From: Laura Gibbons
Sent: 14 May 2018 15:38
To: Planning.Responses
Subject: RE: Planning Consultation on: Y/25/18/HH

APPLICATION Y/25/18/HH

Site Address: 17 Park Drive Yapton BN18 0JF

Description of Works: Single storey extension to the rear of the property

PROJECT TITLE		DRAWING TITLE		No	REVISION	DATE
Proposed Extension at 17 Park Drive Yapton West Sussex BN18 0JF		Proposed Plans				
		STATUS	Planning Application			
		SCALE	1:100 @ A3	DATE	02.03.2018	
		DRAWN BY	DE	DRAWINGS	PA-273-06

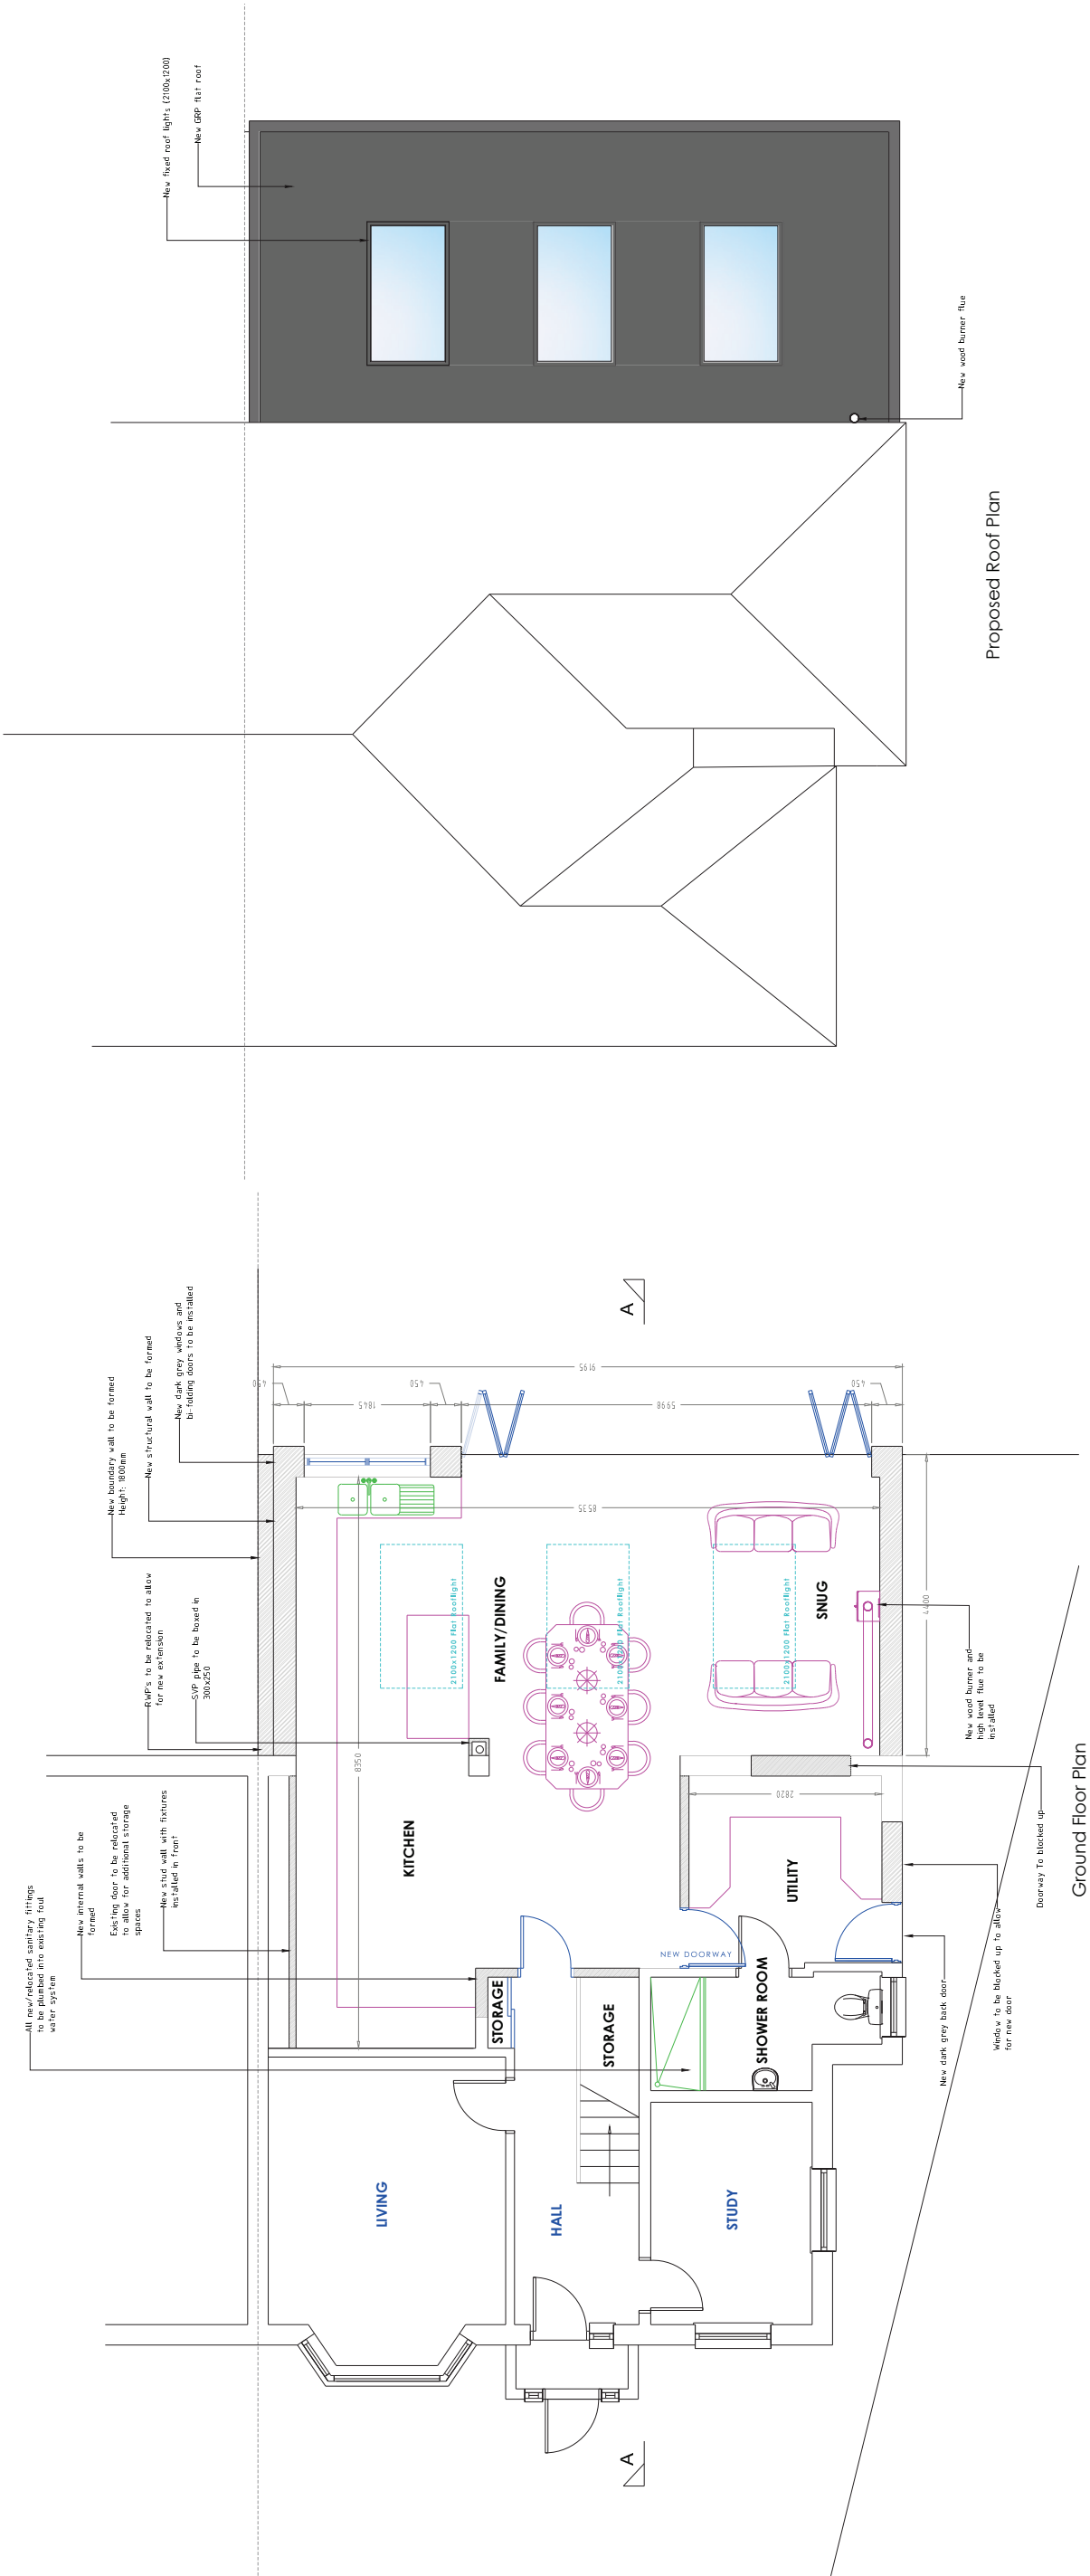
It should be noted that there is a Southern Water Foul Sewer running through the rear garden. Therefore, early consultation with Southern Water to determine its exact location is recommended.
